Submission No.			042	
Organisation Name or Name of Submitter			Charlemont and Dartmouth Community Group (CDCG), General Area Submission (Agent - MacCabe Durney Barnes)

Item No.	Section Ref.	Page No.	Observation Statement	TII Response
Letter Re: Railway Order Application - Metro North: Estuary through Swords, Dublin Airport, Ballymun, Glasnevin and City Centre to Charlemont, Co. Dublin: Railway (Metrolink-Estuary to Charlemont via Dublin Airport) Order 2022				
1	2. Executive Summary	2	The Charlemont and Dartmouth Community Group (CDCG) is in support of the overall Metrolink project. However, we believe that the section of the project between St. Stephen’s Green and Charlemont is a €650m duplication of infrastructure that is not justified on many very important grounds.	<p>The Board is not responsible for any decisions in relation to the funding the Project. It is solely responsible for assessing whether the Project is consistent with proper planning and sustainable development and that its effects on the environment are acceptable.</p> <p>The responsibility for funding the Project lies with the NTA, the Government and ultimately the Oireachtas. It has received all necessary approv

CHARLEMONT STATION - CROSS SECTION

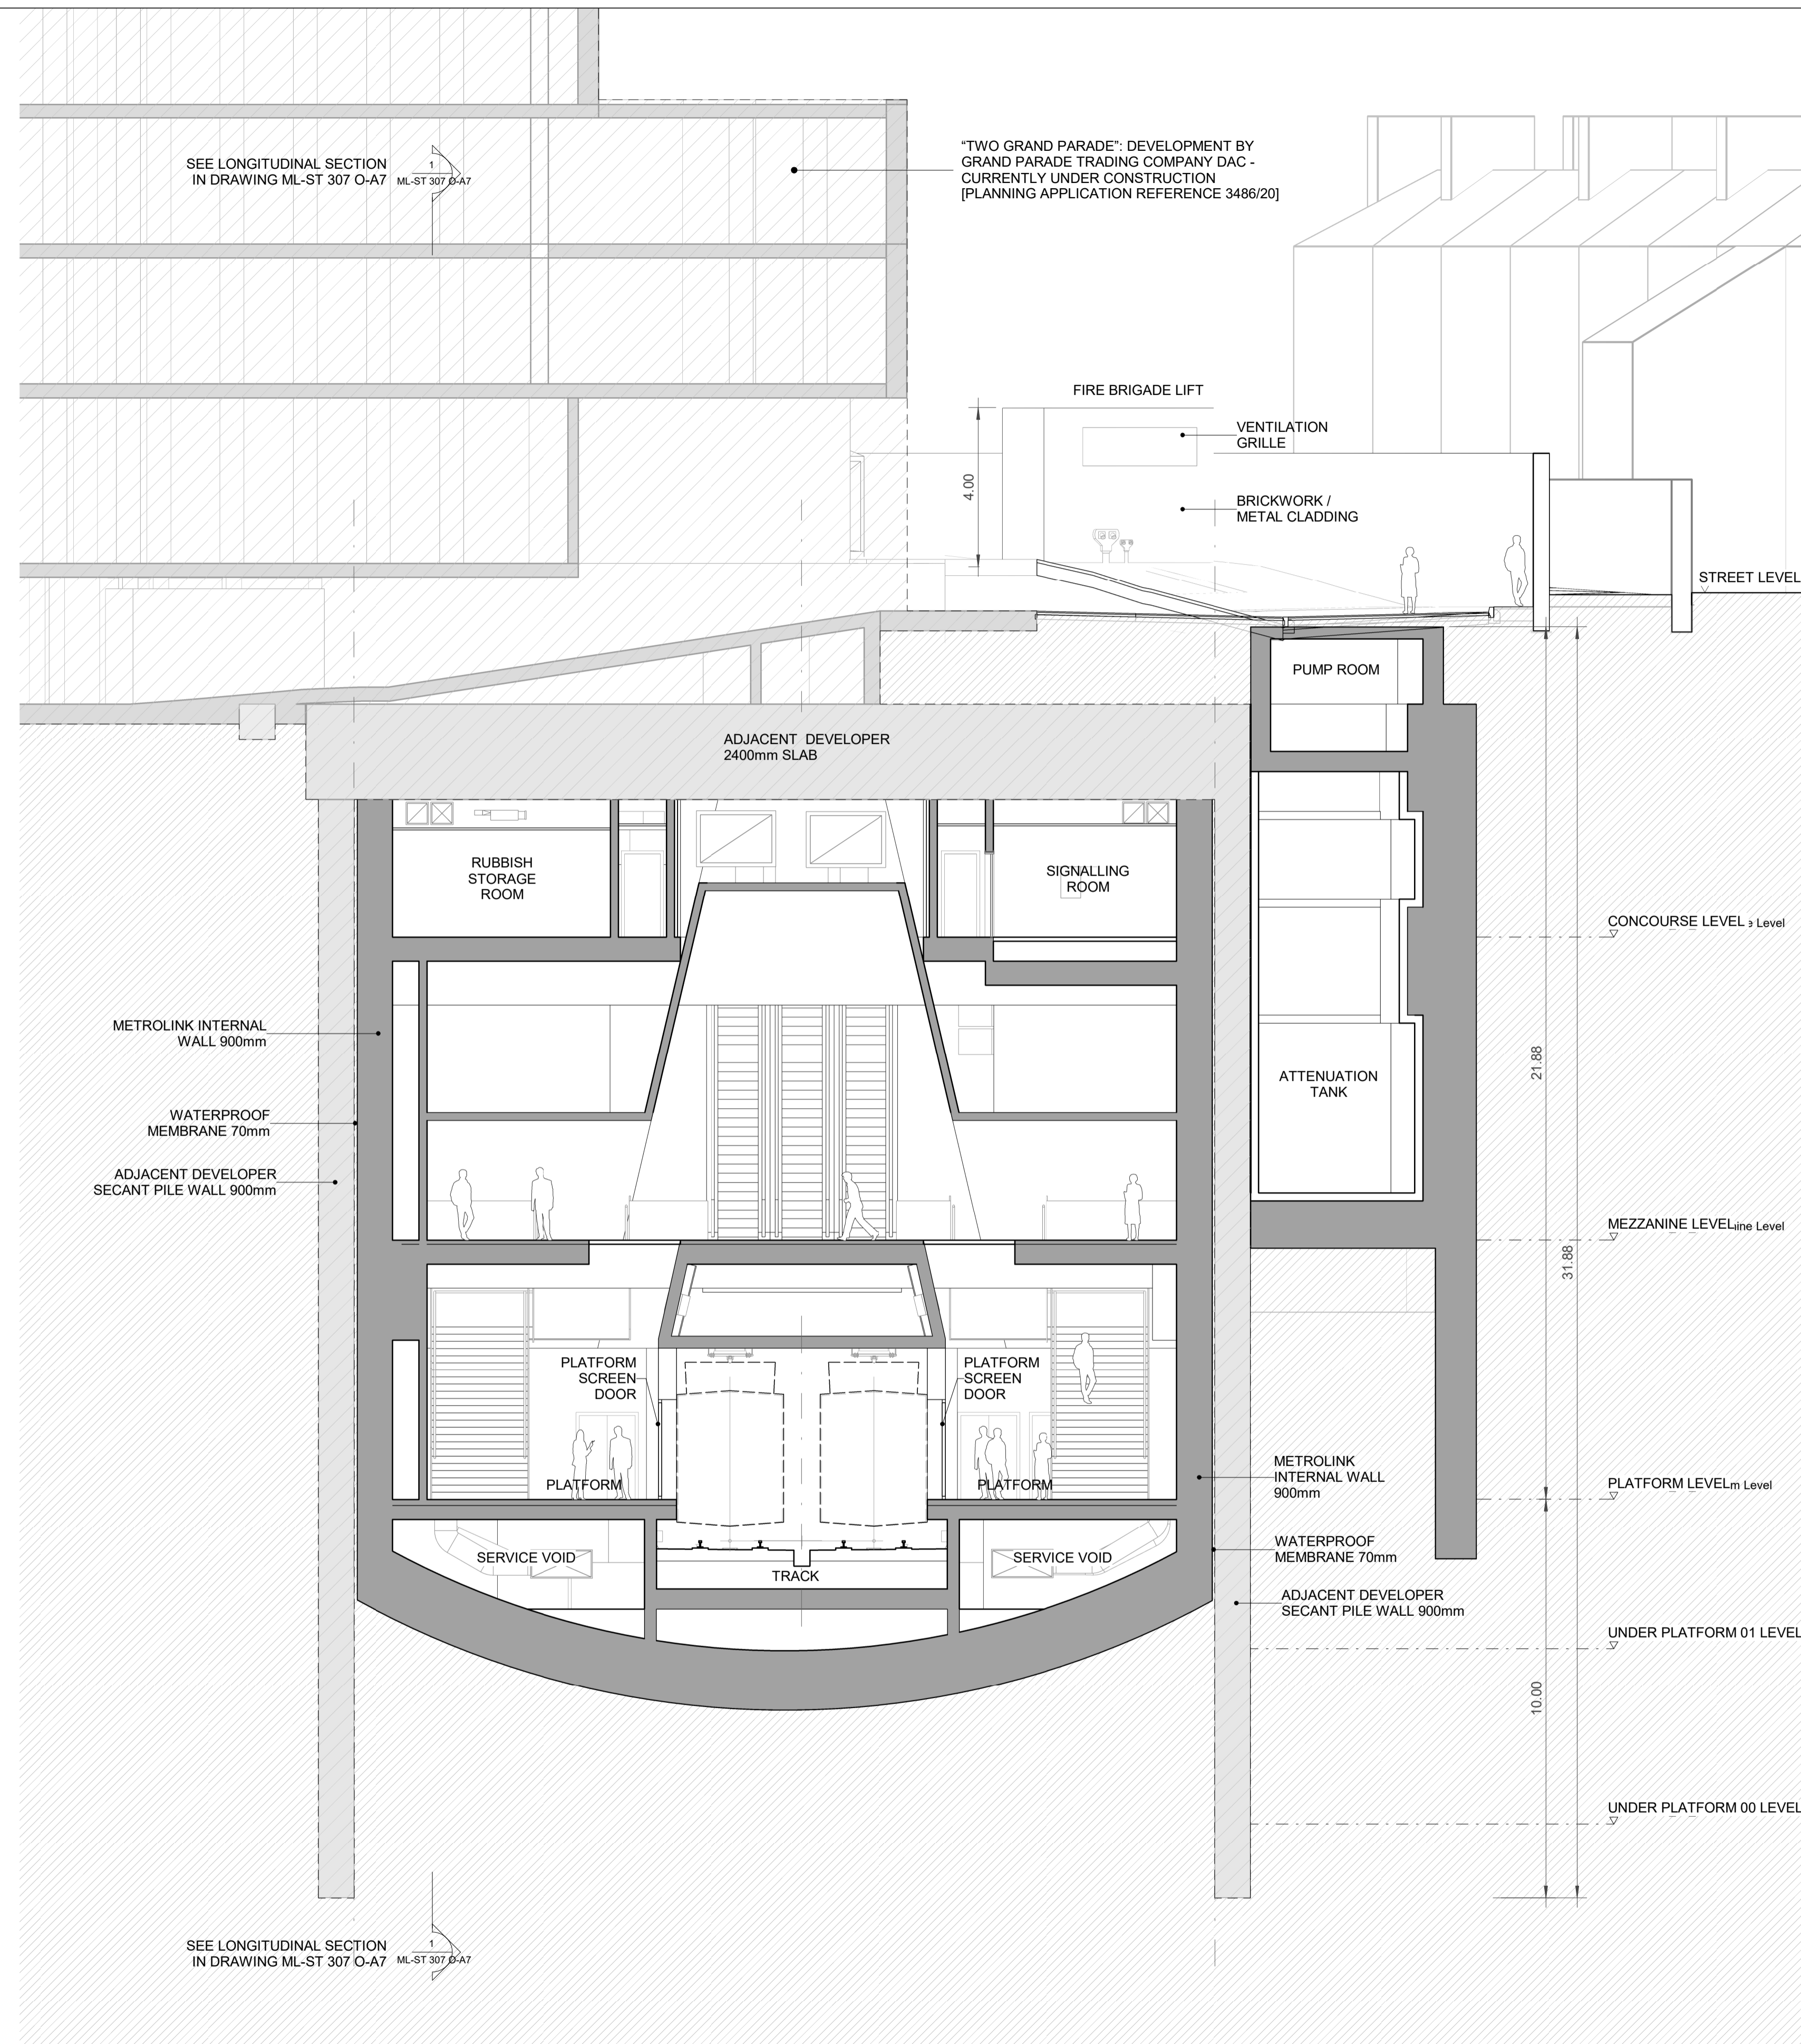
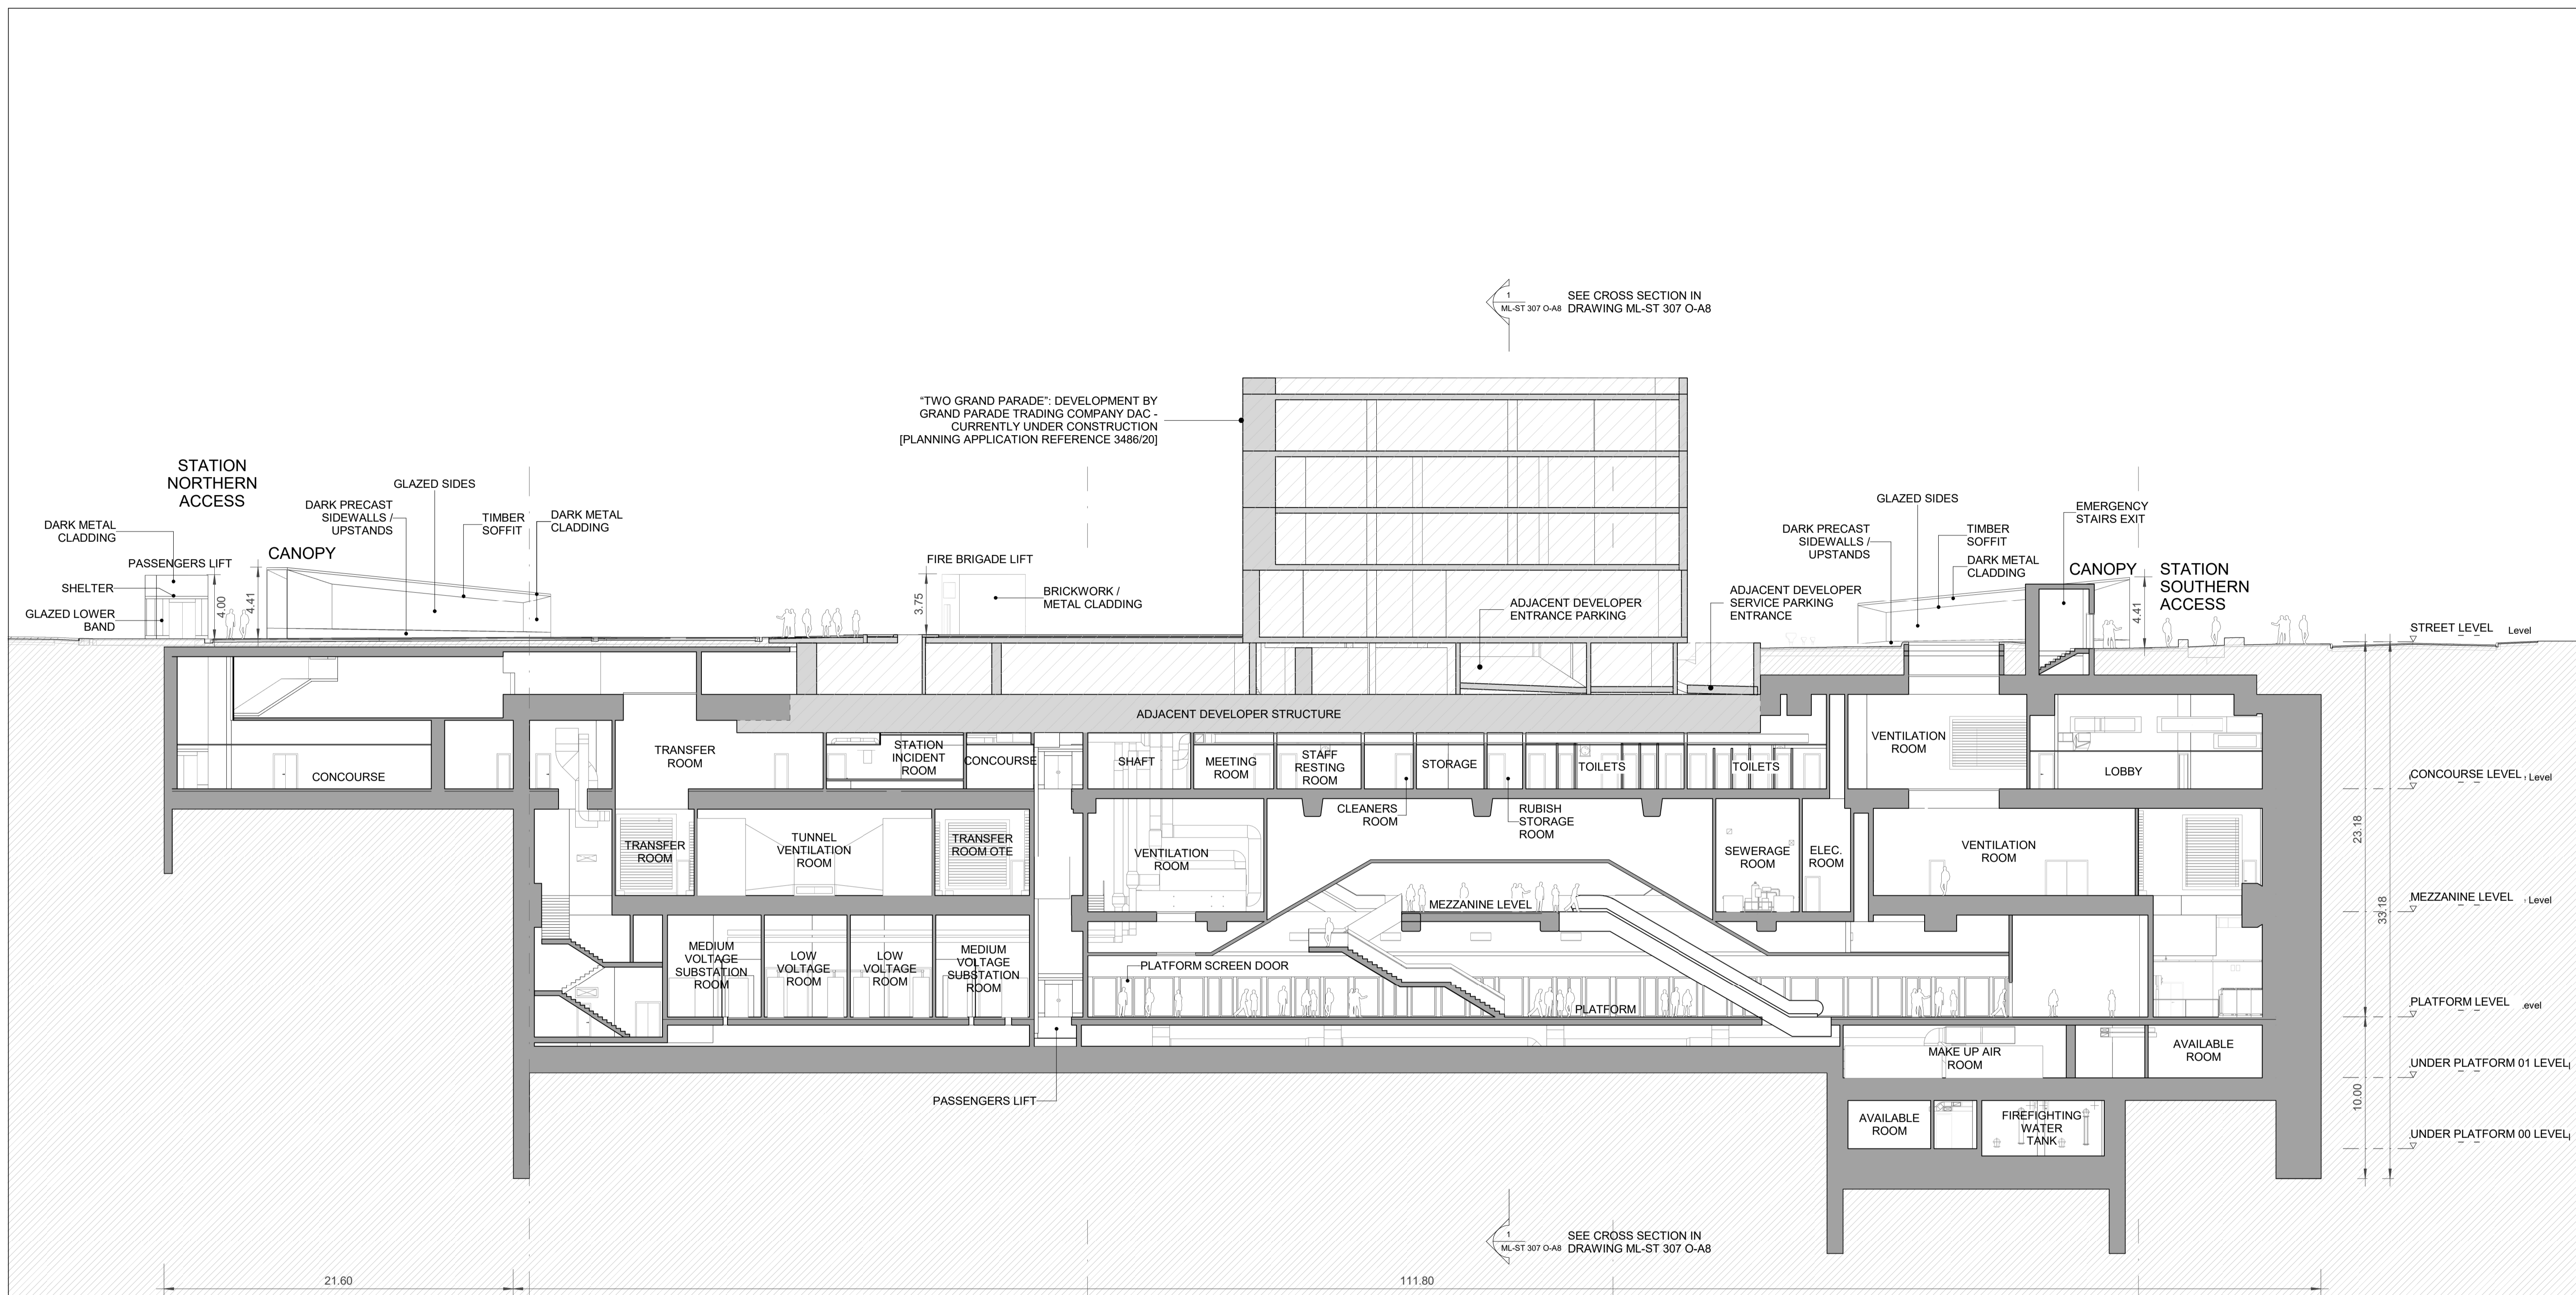
7	2. Executive Summary  Charlemont Station Box work are not described in the Rail Order Application (EIA Project Splitting)	4	The enabling works and construction of the station box at Charlemont, which have already been undertaken, are not described in the Application as forming part of the subject Rail Order, Under the EIA Directive, an EIA must consider the direct, indirect and cumulative effects of all aspects of the development. On this point alone, the entirety of the Rail Order Application is legally unsafe.	<p>The MetroLink enabling works constructed as part of the Hines development has the benefit of planning permission which was granted in April 2019. The station box location was not fixed by the Charlemont Development, but had been identified previously as part of the alignment studies designed to deliver on the objectives of the then GDA Transport Strategy. The preferred route for MetroLink was published in March 2019 following a comprehensive route options study. The preferred route was based on the emerging preferred route for the scheme which included a station at Charlemont. The Charlemont Metro Enabling Works were constructed to enable the Charlemont Development to proceed whilst simultaneously ensuring there was an option available to construct a station at Charlemont that avoided unnecessary demolition, took advantage of an available site, provided infrastructure that is integrated with planned development rather than necessitating later changes and retrospective adjustments to a new development or even possible demolition of the new development, whilst providing protected provision for the future extension of the scheme south, if required.</p> <p>There is no inconsistency with the EIA Directive. All options remain open to the Board in relation to this location. The critical factor in favour of the station at this location are the policy decisions and supporting analysis outlined above and not the permitted enabling works.</p> <p>TII rejects the assertion that the inclusion of a roof slab at Two Grand Parade has prejudiced the EIA process. The MetroLink Enabling Works were a modest change to the Two Grand Parade design that preserved the option to deliver a station at the location identified in the Emerging Preferred Route Report and was fully within the Board's remit as part of its consideration of the proper planning and sustainable development of Dublin City.</p> <p>The decision to grant permission for Two Grand Parade, which included the MetroLink Enabling Works, was challenged by way of judicial review, but the judicial review was withdrawn. The objections now raised attack the validity of that decision, which is prohibited by Section 50 of the Planning and Development Act 2000.</p>

8	2. Executive Summary  Charlemont Station Box Not Permitted/ Unauthorised Development	4	<p>The current Railway Order and associated EIAR acknowledges that the enabling works including the construction of the Station Box at Charlemont has already occurred. TII appear to suggest that these works were permitted under the planning permission for the Office building at 2 Grand Parade. That commercial office development required normal planning permission to be obtained under the Planning and Development Act 2000. However, the Metro Station Box works are "railway works" and cannot be granted permission under that Act. Instead, they require a separate application for, and grant of, a Railway Order under the Transport (Railway Infrastructure) Act 2001. No Railway Order was obtained for the Charlemont Metro Station Box and therefore these railway works were not authorised and could not be lawfully undertaken.</p> <p>Moreover, the Charlemont Station Box is an unauthorised development that also required an EIA and as such, under legislation, the Board is compelled to refuse to consider any application for its retention. Clearly Charlemont Station is an integral part of the Metrolink proposal and the subject Rail Order Application. The Board, therefore, cannot grant the current Rail Order as to do so would a) facilitate the circumvention of the EIA Directive by the splitting of projects and b) amount to a retention permission which it is compelled to refuse. Effectively, Charlemont Station cannot be considered as usable for the Metrolink project because it will remain legally unsafe.</p>	<p>The claim -that a Railway Order is needed to authorise any works that fall within the definition of railway works is mistaken. The definition of "railway works" is "any works required for the purposes of a railway or any part of a railway, including works ancillary to the purposes aforesaid such as parking by buses or by persons using vehicles who intend to complete their journey by railway, and relocation of utilities, and in this definition “works” includes any act or operation of construction, excavation, tunnelling, demolition, extension, alteration, reinstatement, reconstruction, making good, repair."</p> <p>The definition is expansive and is designed to facilitate the inclusion of ancillary development within a railway order. It is not intended to preclude the authorisation of ancillary development through other processes. The MetroLink Enabling Works are like any number of other works that ancillary to a railway, like power supply, roads (in the case of on-street light rail) or the buildings that provide support for light rail electrification.</p> <p>Please refer to response (7) above.</p>

9	2. Executive Summary - Charlemont Station Box Not Permitted/ Unauthorised Development	4	<p>This design and alignment of the Charlemont Station Box is very significantly different to the proposal in the Preferred Route consultation. No notice was made to the public of the proposed changes and there was no opportunity for affected parties to make comment.</p> <p>In the event of a future Luas tie-in, which the NTA/TII says "will remain a likely option for the future", the implications of the now locked-in (built) station alignment are profound. It will result in the demolition of houses on Manders Terrace, Charleston Road and will require the demolition of 11 houses and 24 apartments on Oakley Road. None of these houses and apartments would be demolished under the earlier design that was presented in the Preferred Route Consultation.</p> <p>Not only was no notice given to affected parties, but the implications of the new alignment are now known to the Applicant and yet it is not presented in the EIAR of the Rail Order Application. Case law has clearly established that an EIAR must "...<i>take account, as far as practically possible, of potential later phases...</i>". The EIAR is again inadequate and disingenuous in not presenting the known facts.</p>	<p>Response (6) explains why TII do not consider the design and alignment of the station box at Charlemont applied for by the Railway Order application differs significantly to that consulted on at the Preferred Route stage of the Project.</p> <p>The station box at Charlemont allows for a future tie into the Luas Green Line should it be determined in the future that through running metro services to Sandyford is the required solution to address the public transport needs to the south of the city. It is misleading to say that there are profound implications associated with the "station alignment" being "locked-in". Any piece of infrastructure once constructed is "locked -in" i.e. it cannot move, but this "station alignment" does not lock in future extensions to the south. The Charlemont station location will allow for future alignments to the south, south west or south east as required in the future. The statement that the decision to locate a station at Charlemont will result in the demolition of properties in Ranelagh is not correct for the reasons explained by response (6) above.</p>

12	3.1.2 Construction Phase	6	These limits of deviation may be very significant in on a tight site like Charlemont Station.	The station at Charlemont will be carried out within the footprint of the MetroLink Enabling Works unless modified by An Bord Pleanála. Assuming that the Board grants a Railway Order for an unmodified design at this location, TII will accept a condition that restricts the Limits of Deviation for this station.
13	3.1.3 Scheme Detail	7	Overall, we consider the detail of the railway order application to be inadequate. These inadequacies are considered throughout this submission. The lack of detail is in no small part due to the procurement method to be adopted, which is a 'design and build'. The first component is 'design' which should be undertaken prior to submission for a railway order consent. Our clients have been advised by RINA that only about 30% of the detail will be presented in the Rail Order Application and therefore it is impossible for the residents to be able to assess the impact of the proposal. By following a 'design and build' approach NTA/TII is failing to provide the required level of detail under which a Rail Order could be granted by An Bord Pleanála (ABP).	<p>Please refer to response (10) above.</p> <p>It is not clear to what the "30%" is referring to, but as explained by response (10) above, a Preliminary Design provides the required level of detail to inform a Railway Order application. A Detailed Design is needed for construction but not to inform an EIAR and a Railway Order application.</p>
